**22/01144/F**

**OS Parcel 5700 South West of Grange Farm Street Through Little Chesterton**

Full planning application for the erection of a new high quality combined research, development and production facility comprising of Class B2 floorspace and ancillary office floorspace with associated infrastructure including: formation of signal-controlled vehicular access to the A41 and repositioning of existing bus stops; ancillary workshops; staff gym and canteen; security gate house; a building for use as an energy centre (details of the energy generation reserved for future approval); loading bays; service yard; waste management area; external plant; vehicle parking; landscaping including permanent landscaped mounds; sustainable drainage details; together with the demolition of existing agricultural buildings within the red line boundary; and the realignment of an existing watercourse.

# The Biodiversity Metric 2.0 - Calculation Tool

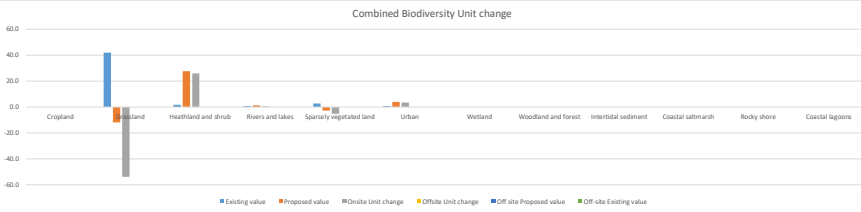
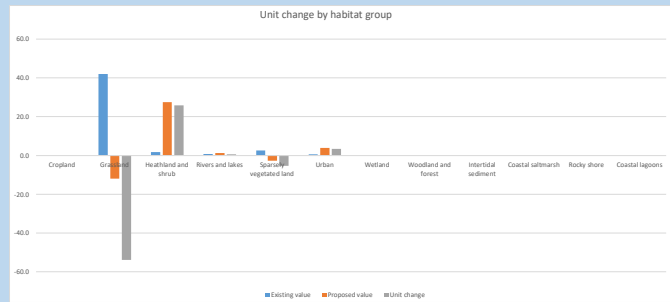
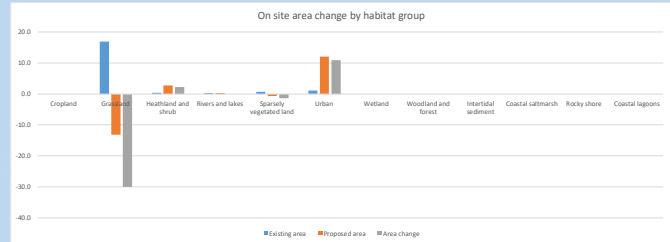
A Biodiversity Net Gain metric spreadsheet has also been provided at ES Appendix 08.2 to illustrate the potential net gain resulting from this application. This shows a net gain of 4.10% habitat units and 6.71% hedgerow units. Neither of these figures is sufficient since a 10% net gain is required by the Community Nature Plan quoted above and neither figure will provide an adequate buffer to guarantee against an overall net loss in biodiversity.

a) Creation of Other Neutral Grassland – Good condition.

The metric provides five possible condition scores for created habitat, listed here, with their scores afterwards – Poor (1); Fairly Poor (1.5); Moderate (2); Fairly Good (2.5) and Good (3). To select the very highest of those scores, which will provide the most units on the metric, needs a very high level of confidence that the starting point, the creation techniques, and the management techniques will all combine to allow the creation of such high-quality grassland. Factors such as invasive species, recreational impact and nutrient input can also be relevant. It is common for a precautionary approach to be taken, for example by using a Condition score of Moderate (2) or at the most Fairly Good (2.5). To justify a score of Good (3), or of Fairly Good (2.5), we would ask for much more detail on the above issues to be provided than is currently available, and for that detail to be consulted on. Otherwise we would suggest a precautionary score of Moderate (2) is used instead.

b) Creation of Mixed scrub – Good condition

As above, the highest score has been selected without any detail about management techniques being provided. We would ask for much more detail on the above issues to be provided than is currently available, and for that detail to be consulted on. Otherwise we would suggest a precautionary score of Moderate (2) is used instead.

1 Production Area Roof  
1 : 500

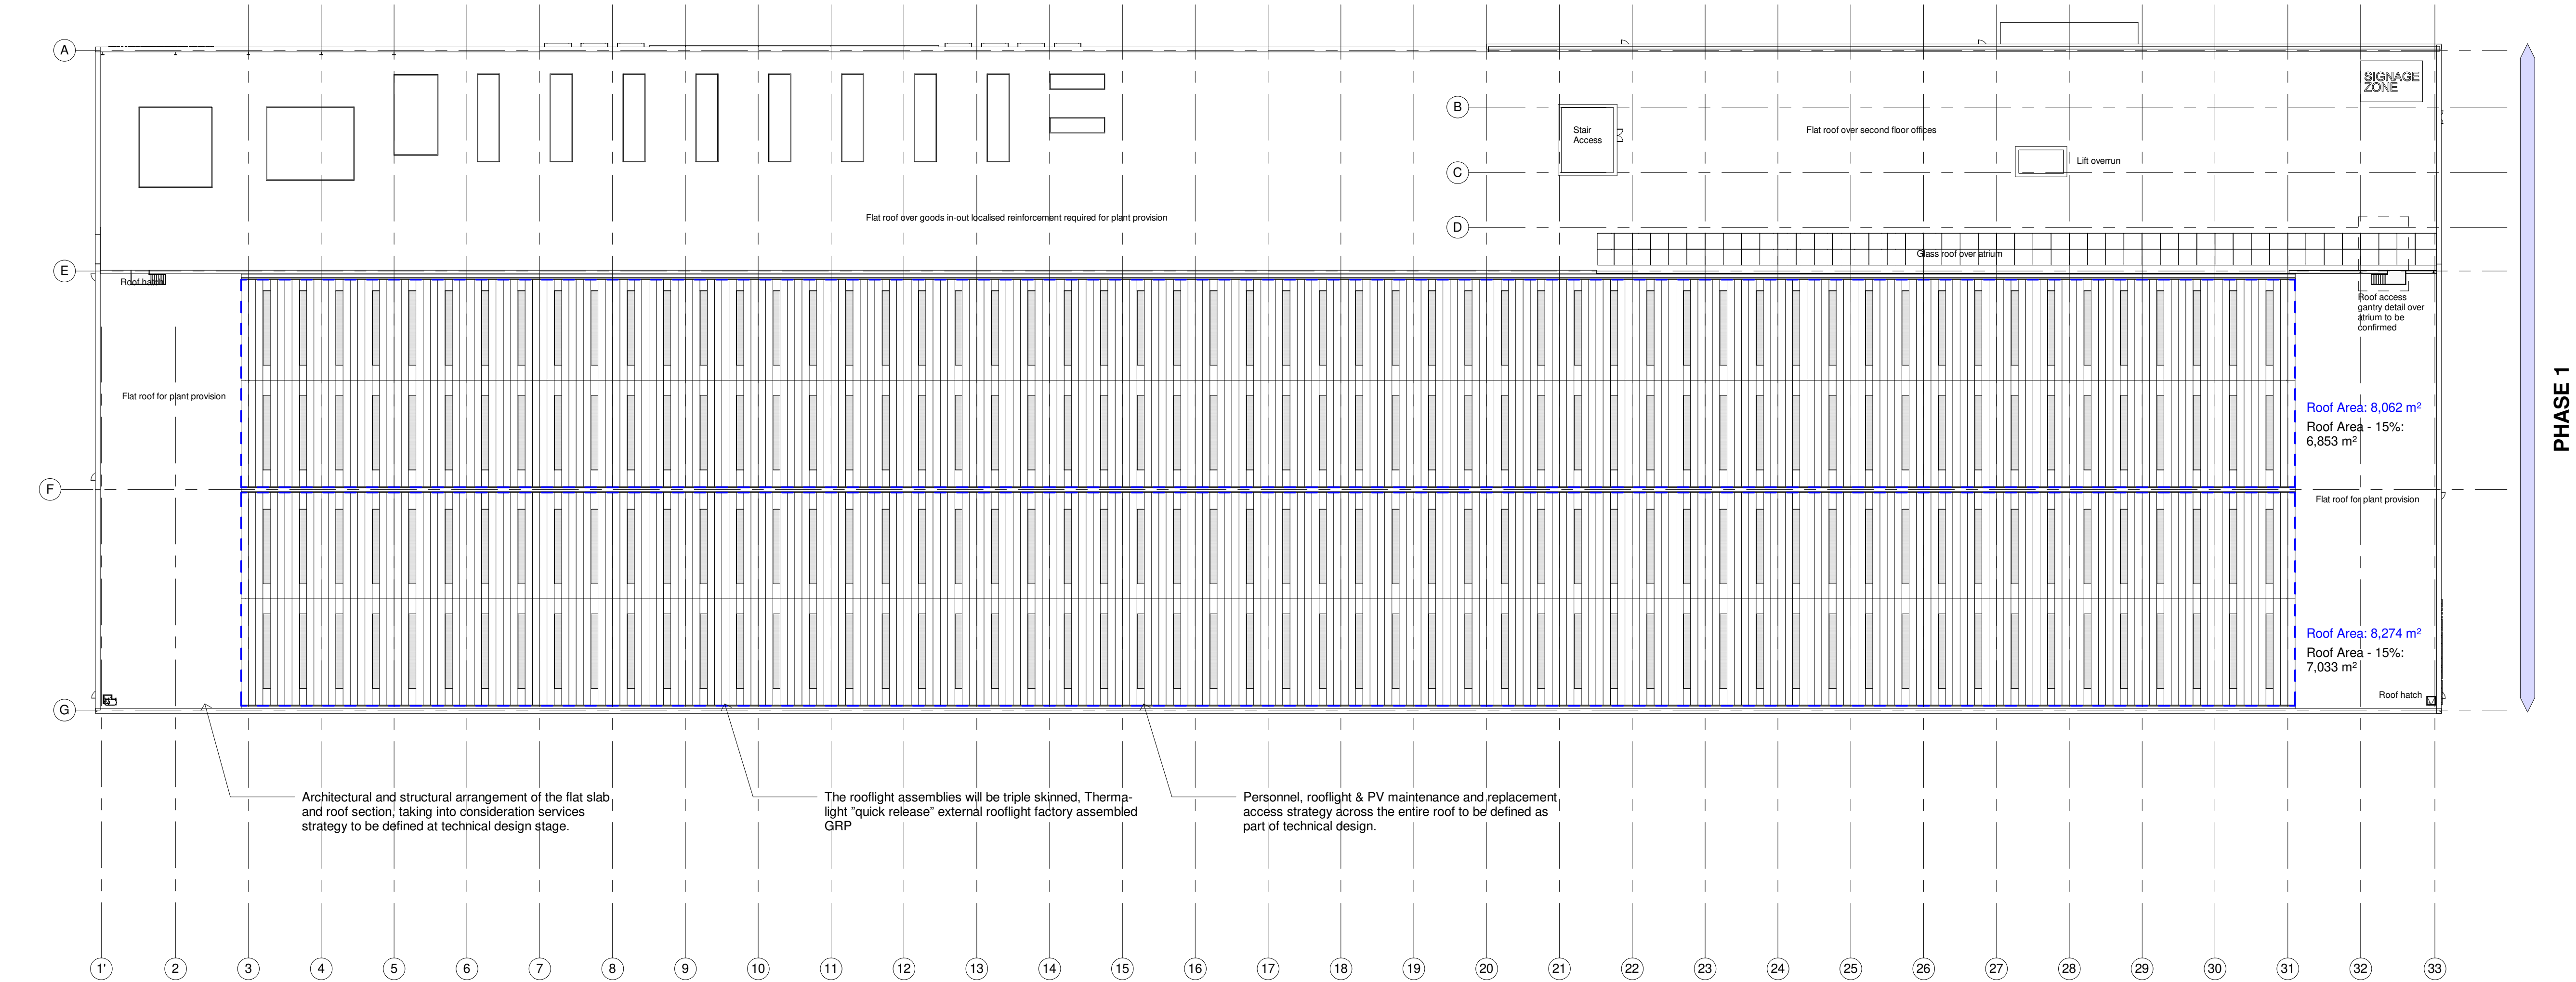
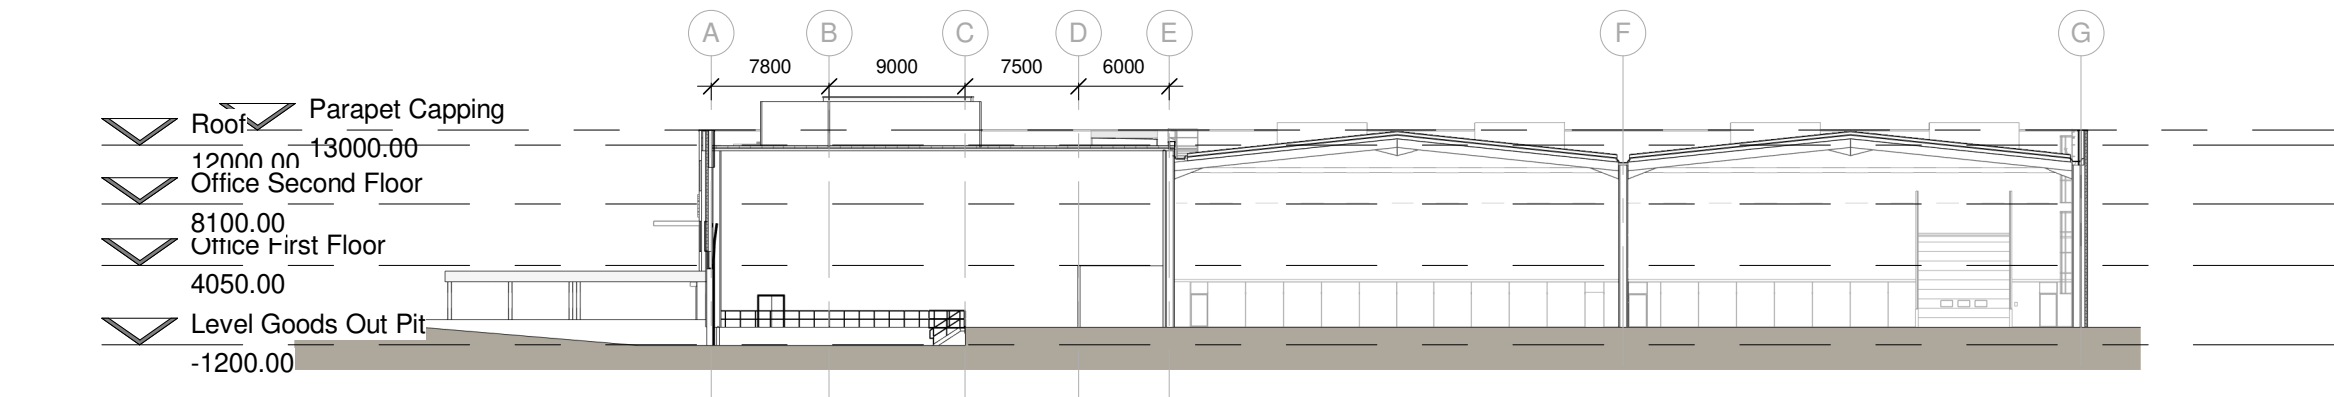
We note that *"It is proposed that 18 % of the roof will be covered with solar PV Cells"* (Planning Statement paragraph 6.54).

In the event that this application is approved we would suggest that that developers should be required to maximise the provision of either green rooves or PV cells on any remaining roof space. Research shows that green rooves can provide valuable habitats for wildlife (<https://livingroofs.org/biodiversity-and-wildlife/>). According to [www.livingroofs.org](http://www.livingroofs.org), a good green roof designed for biodiversity should include a varied substrate depth planted with a wide range of wildflowers suitable for dry meadows. The inclusion of buildings with green rooves would be another means of increasing biodiversity within the proposed development.
